Appendix E - Schedule of Design Guide Changes

Figure 5: Land use

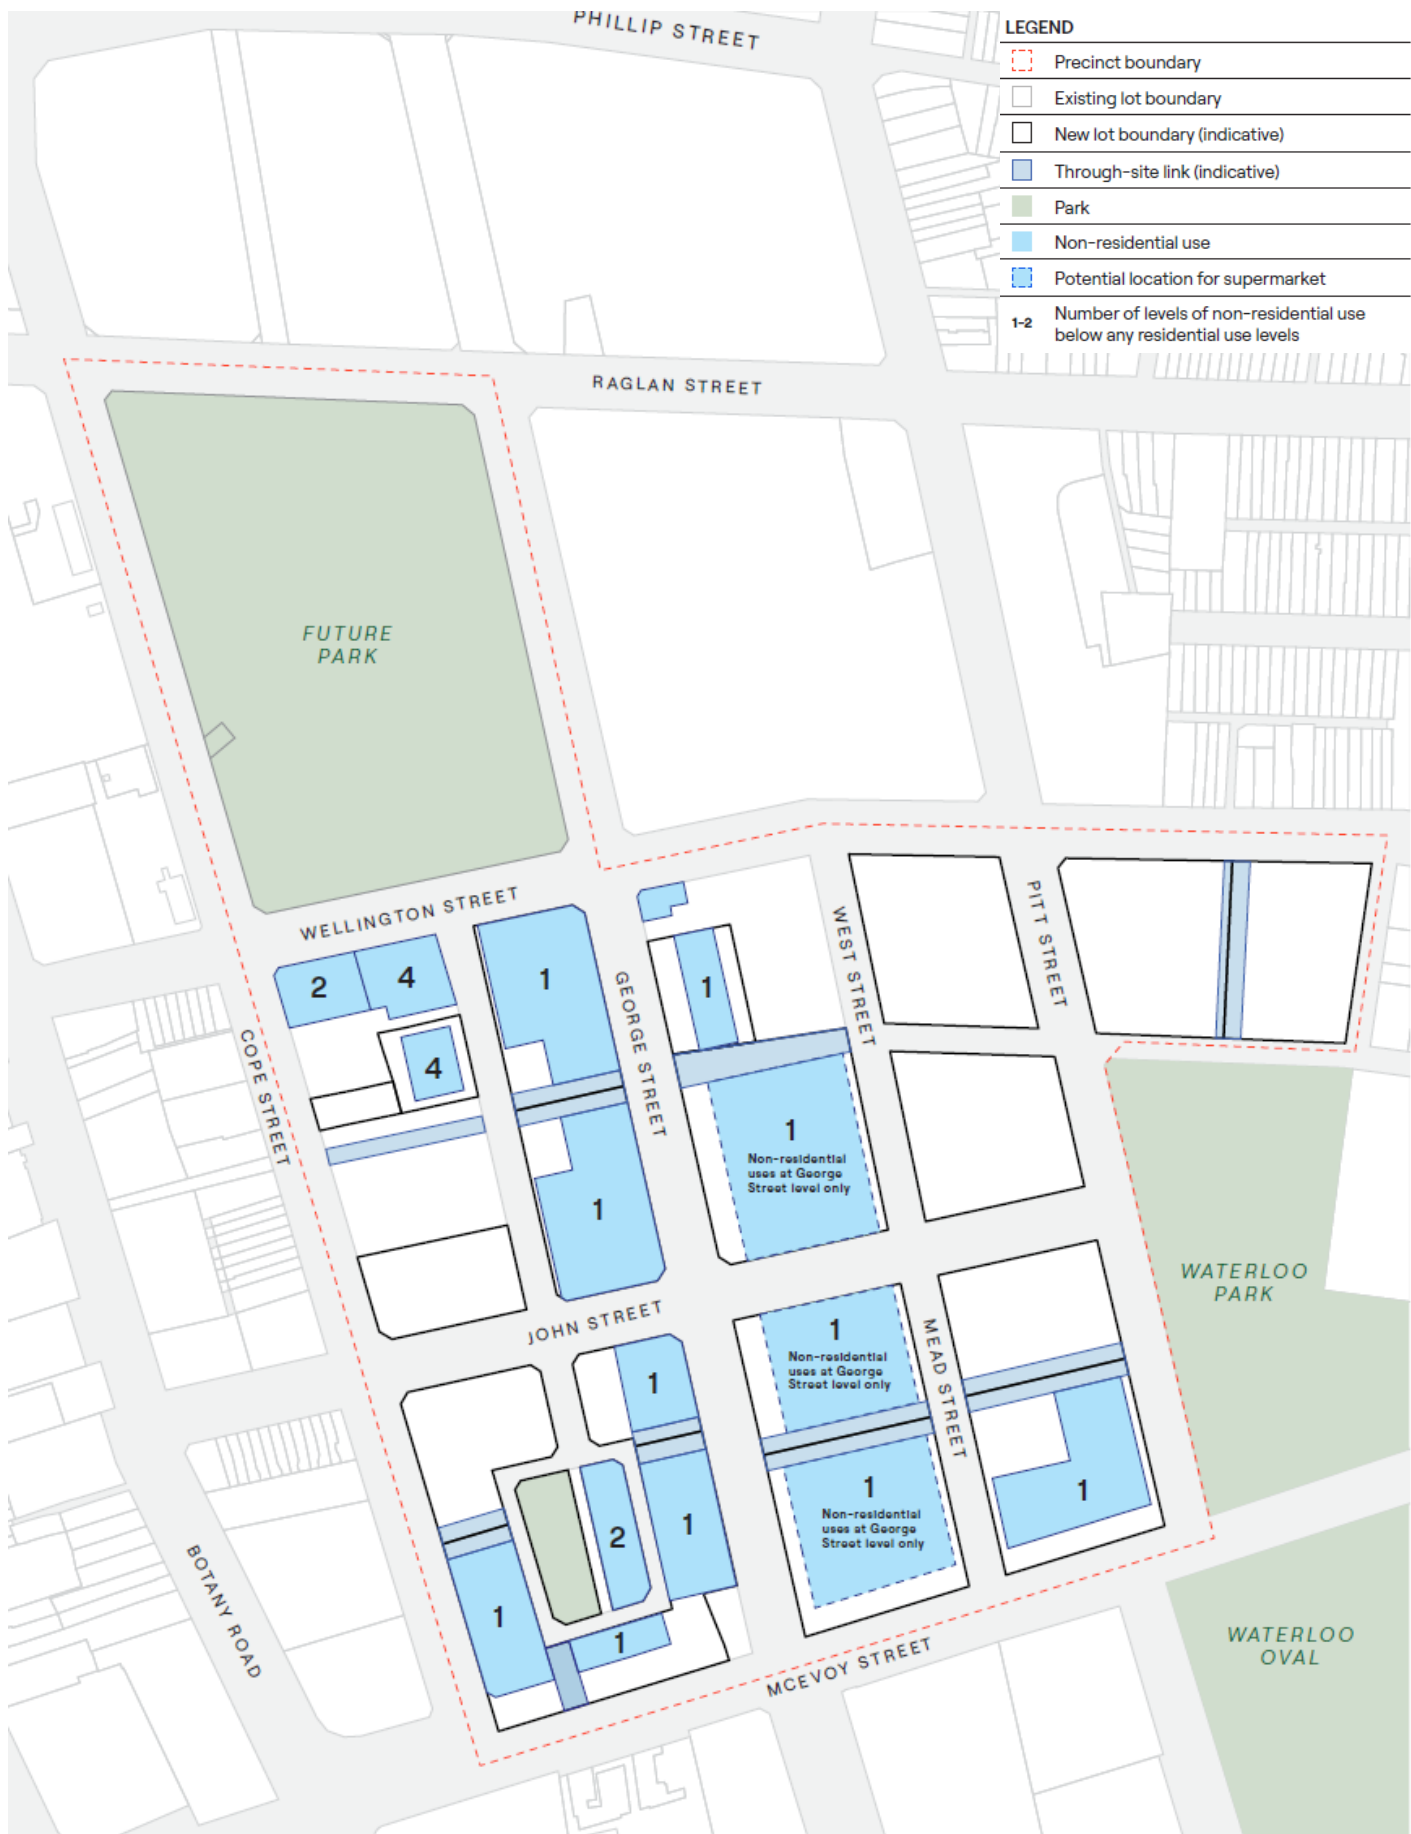
5. Land Use		
Figure 5	Reinstate 'Park' to legend	This has been added to the Revised Design Guide (refer to Appendix D).
5.3.4	Reinstate requirement of active frontages to be consistent with Active Frontage controls of SDCP 2012	Clause 7.27 Active Street Frontages of the Sydney Local Environmental Plan 2012 (the LEP) includes site specific provisions relating to active street frontages. It is noted the Sydney Development Control Plan 2012 (the DCP) limits the proposed uses that are counted as "active". It is therefore proposed to delete this provision to enable further uses to be provided on the site, beyond what is identified within the DCP, consistent with Clause 7.27 of the LEP. Therefore, no further changes to the submitted Revised Design Guide are proposed in this regard.

Figure 18: Carpark locations and entries

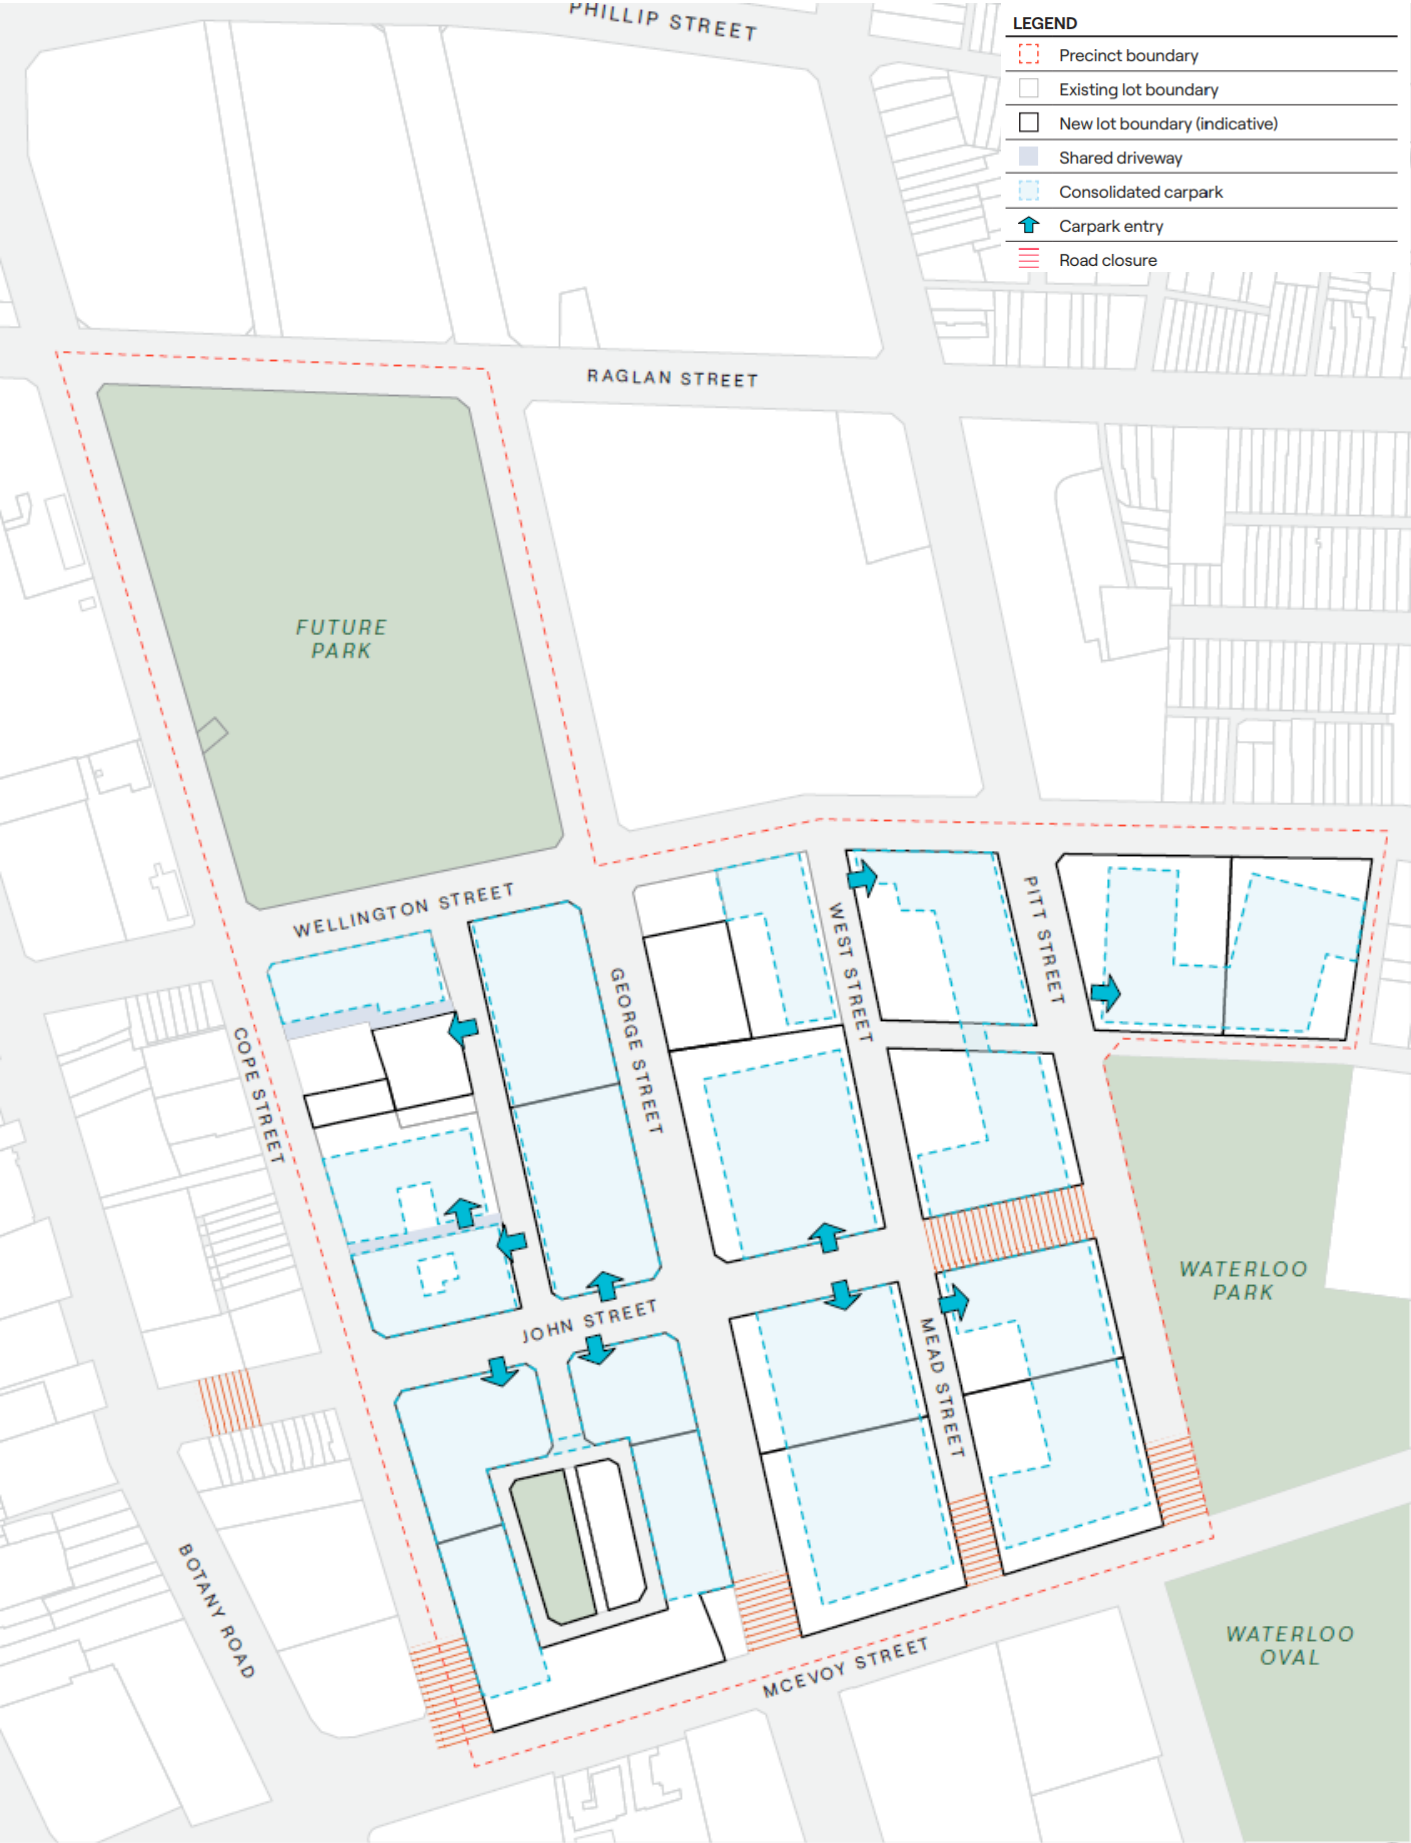
Topic/Section	Comment	Applicant Response
Section 9.2	Insert control 9.2(15) to provide flexibility to consolidate the proposed car share parking spaces within Block 9.	<i>Reason for update</i> As detailed in the Transport Impact Assessment (refer to Appendix CC of the submitted EIS), retail car parking within the precinct is proposed to be consolidated within Block 9. It is also proposed that the car share parking spaces allocated to each block may be consolidated within the Block 9 basement, as this will be the publicly accessible basement within the precinct.

Figure 8(i): STREET CROSS SECTION – John Street

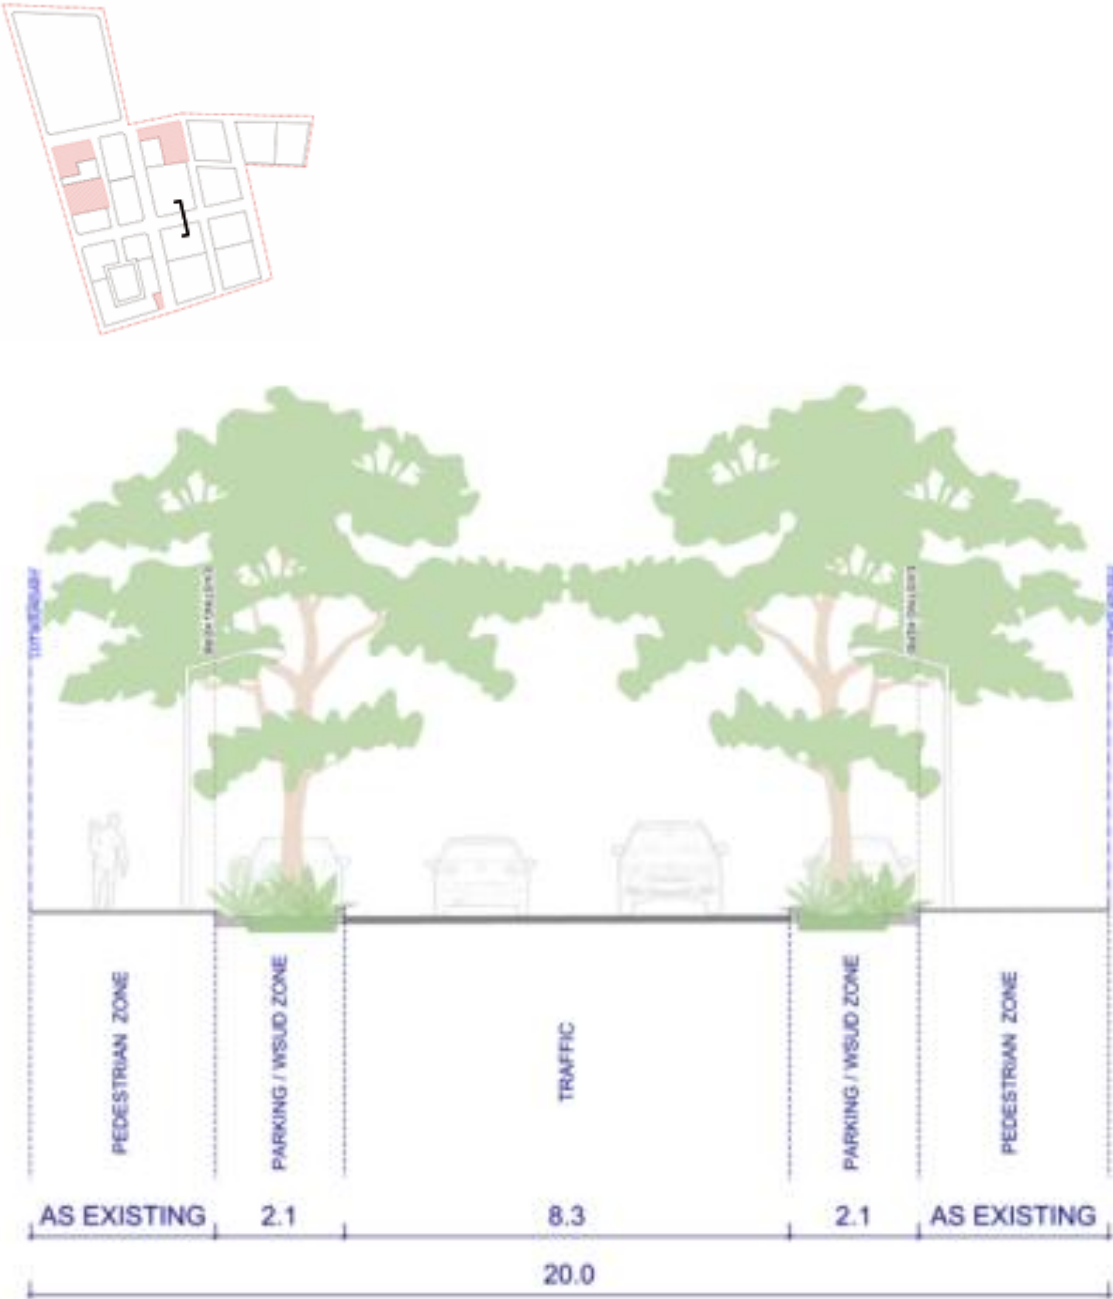
7.3.2(3)	The inclusion of the proposed wording implies that any changed traffic arrangements would be at the City's or TfNSW's cost. If the parties agree to these changes in a timely manner, the works should be incorporated with other public domain works. Text change suggested from "left turn into George Street" to "left-in/ left-out arrangement at George Street" which reflects the City's intention to pursue with Transport for NSW in ongoing discussions.	Control 7.3.2 (3) has been updated within the Revised Design Guide from "options for a left turn into George Street" to "options for a left-in/ left-out arrangement at George Street" to reflect the City's intention to pursue the opening with Transport for NSW in ongoing discussions.
Figures 8(a) – (h)	Replacement of street section drawings not supported. Drawings should include context of adjoining buildings from ground to at least two storeys above street wall. Proposed drawings fail to communicate any information relevant to building design or assist in understanding the quality of the public domain. All typical building sections must be reintroduced, accounting for known flood planning levels, privacy provisions at ground level. This is to ensure the Design Guide clearly informs the desired built outcome. Include John Street section (with noted amendments)	The 2022 Design Guide drawings included adjoining buildings as contextual information only and were not intended to represent the focus of the sections. The revised street section drawings are located within Section 7.3 – Street, pedestrian and cycle network, and are primarily intended to illustrate the proposed street environment, including road geometry, pedestrian and cycle infrastructure, and the relationship between the public domain elements. An additional street cross section for John Street has been included in the Revised Design Guide at Figure 8(i) (refer to Appendix D).
